Re: Major Project – Homebush Bay Bridge

ITEM PART 3A PROJECT - HOMEBUSH BAY BRIDGE

The proposed Homebush Bay Bridge from Wentworth Point to Rhodes, is a Part 3A Major Infrastructure Project under the Environmental Planning and Assessment Act (MP10_0192) which has been on public exhibition from Wednesday 21 March until 4 May 2012. The consent authority for the project is either the NSW Minister for Planning and Infrastructure or the Planning Assessment Commission.

ARTIST IMPRESSION OF POTENTIAL OPEN SPACE TREATMENTS AND RELATIONSHIP WITH PROPOSED BRIDGE AND ITS LANDING AT RHODES.

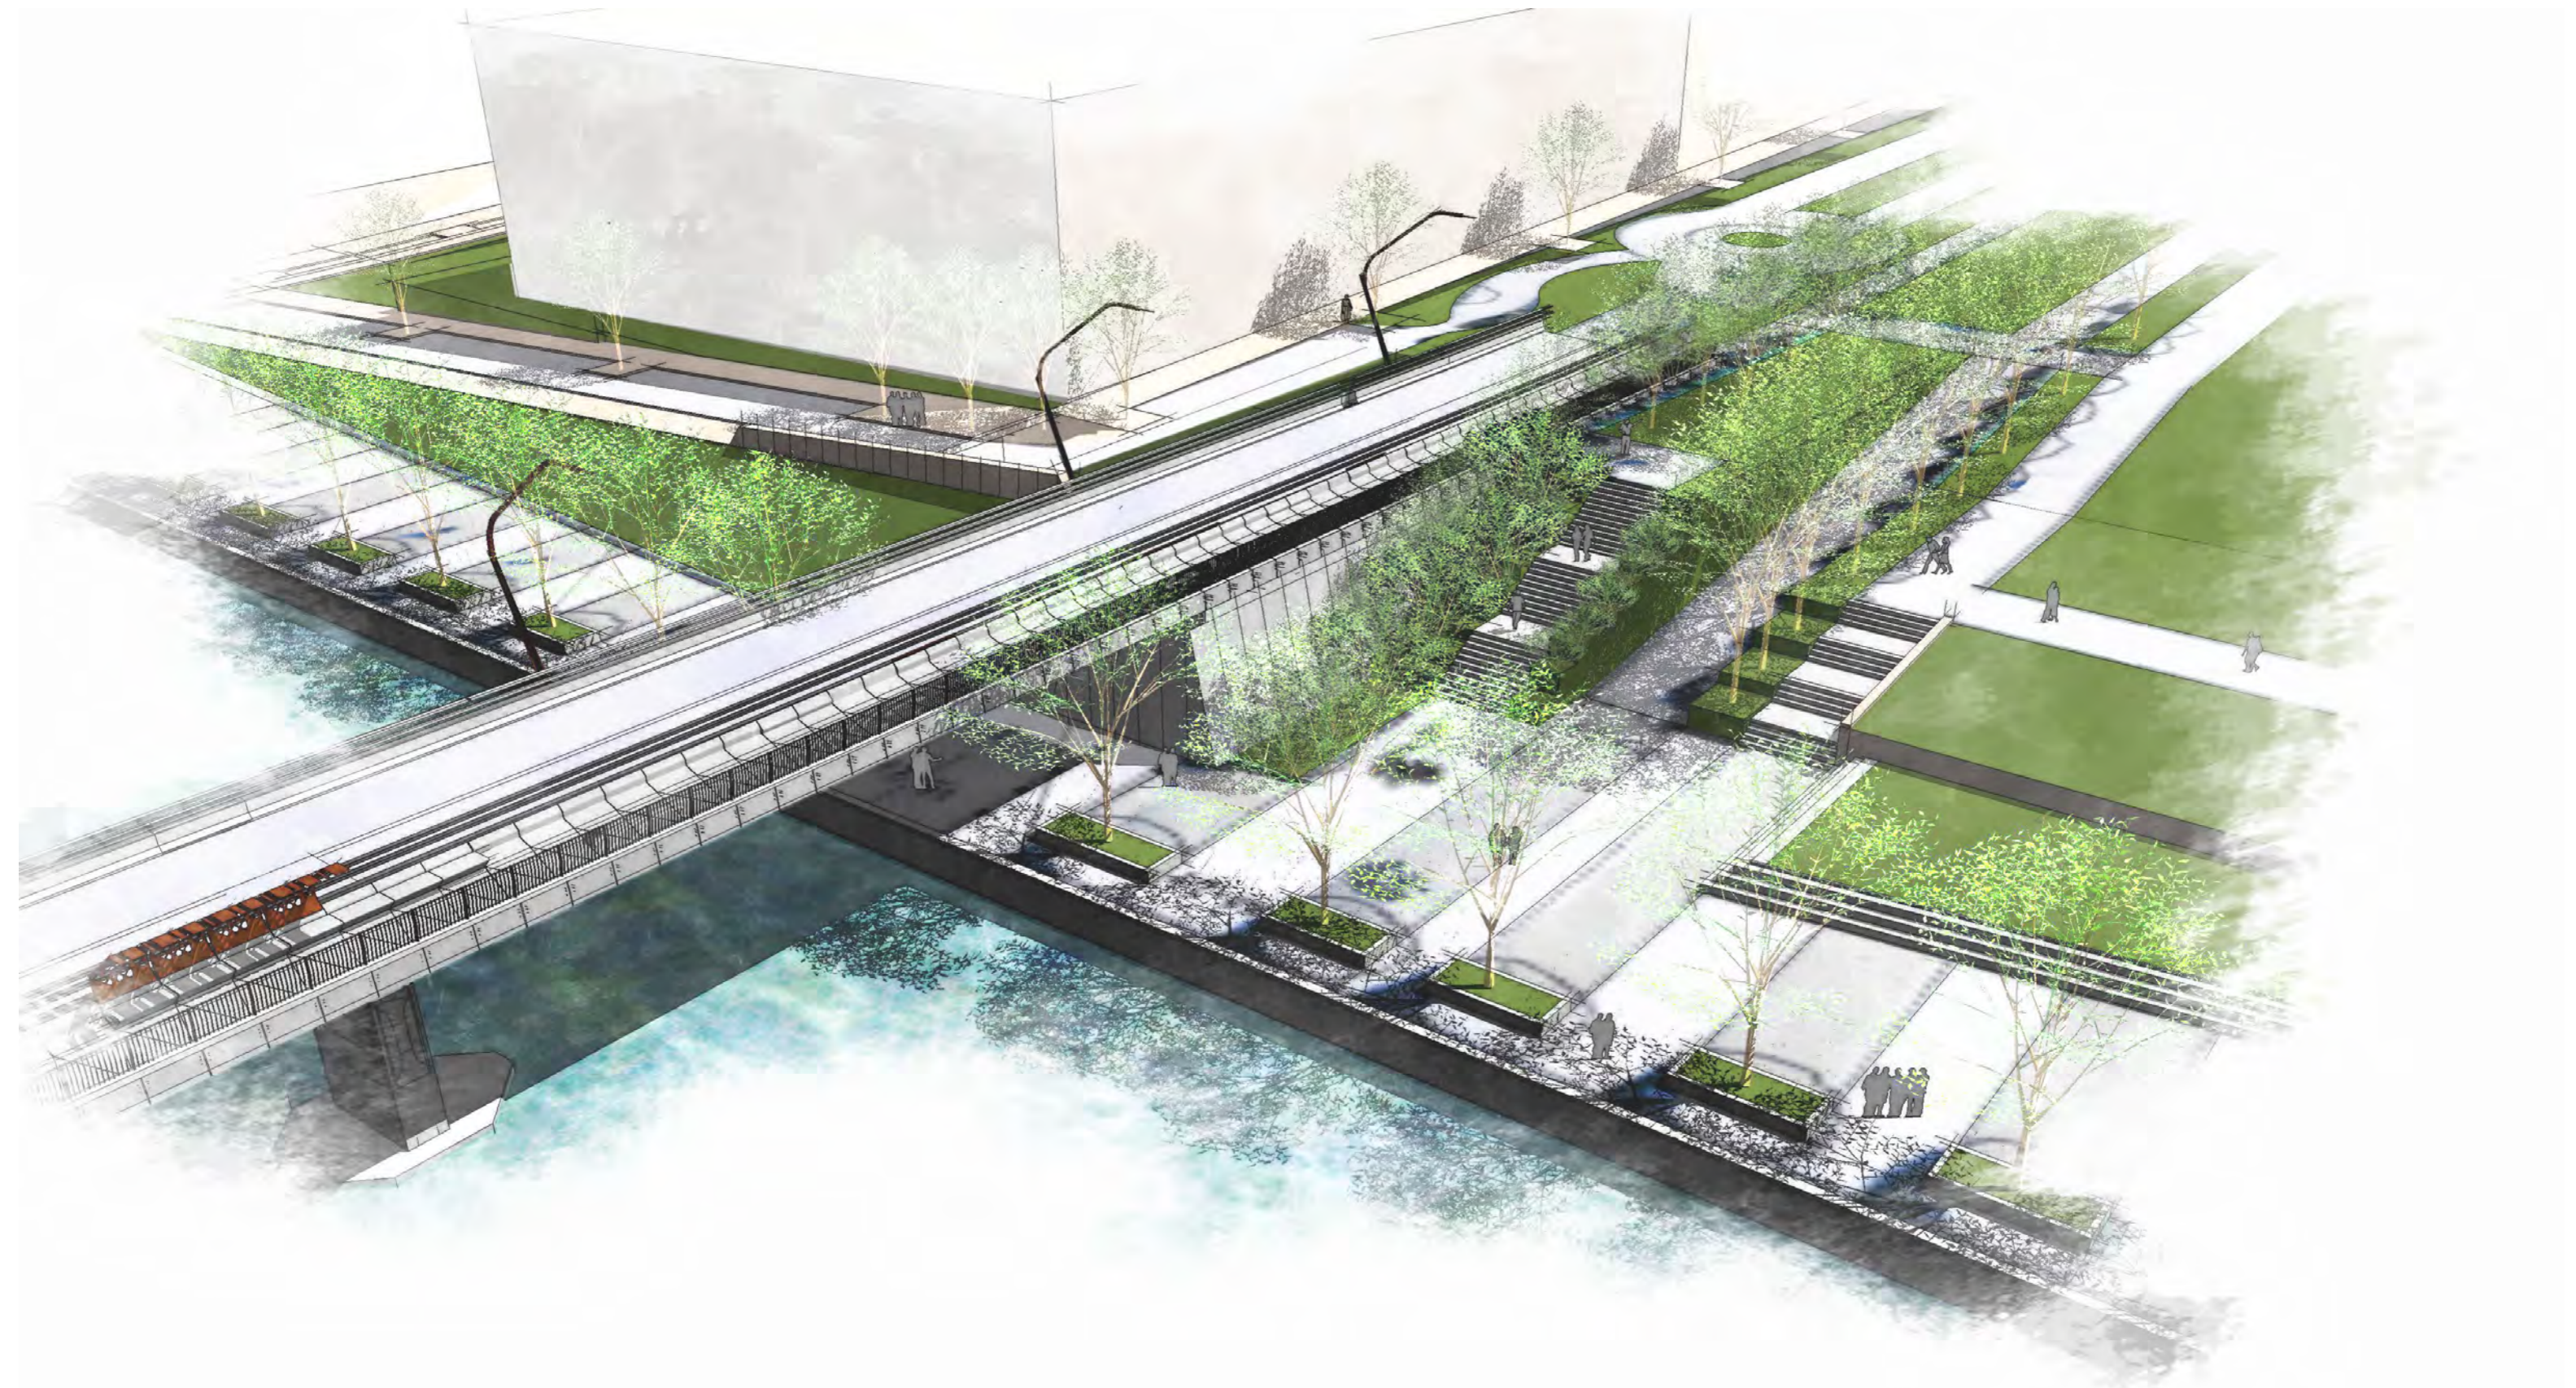
- Information regarding the exact level of the Bridge landing on the Rhodes side and how public open space in and around this landing needs to be designed to ensure amenity, safety, accessibility and an acceptable outcome in visual terms to both adjoining residents, residents of the suburb, future bridge users and the general public given that the site is an identified Strategic Foreshore Site.

It is proposed to land the Bridge at an RL level between 2.8m and 3.5m which is set by the existing height of the sea wall and consideration of sea level rise above that. The proponent has indicated to Council that an RL level of around 3.05m would mean that the bridge landing can be achieved within the foreshore area and still leave sufficient area to provide a designated and separated pedestrian/cyclist crossing point (for people travelling in a North/South direction) which will interface with people walking and cycling onto/off the Bridge, and buses travelling in both directions.

Council's preference would be for the bridge to land at the lowest possible level of 2.8m, as this RL would mean the least impact to Council's foreshore area, both functionally and visually.

However, notwithstanding the many discussions to date, this matter is still not resolved, and documentation of public domain around the Bridge has not been updated in the EA following Council's earlier representations in terms of this issue.

- Concern exists about how the bridge, once a level is determined, will interact with the community centre site. If the bridge is to be approved, it is imperative that conditions of consent require the proponent to contribute to the cost of amending public domain in the areas interfacing with Council's foreshore park and future community centre.
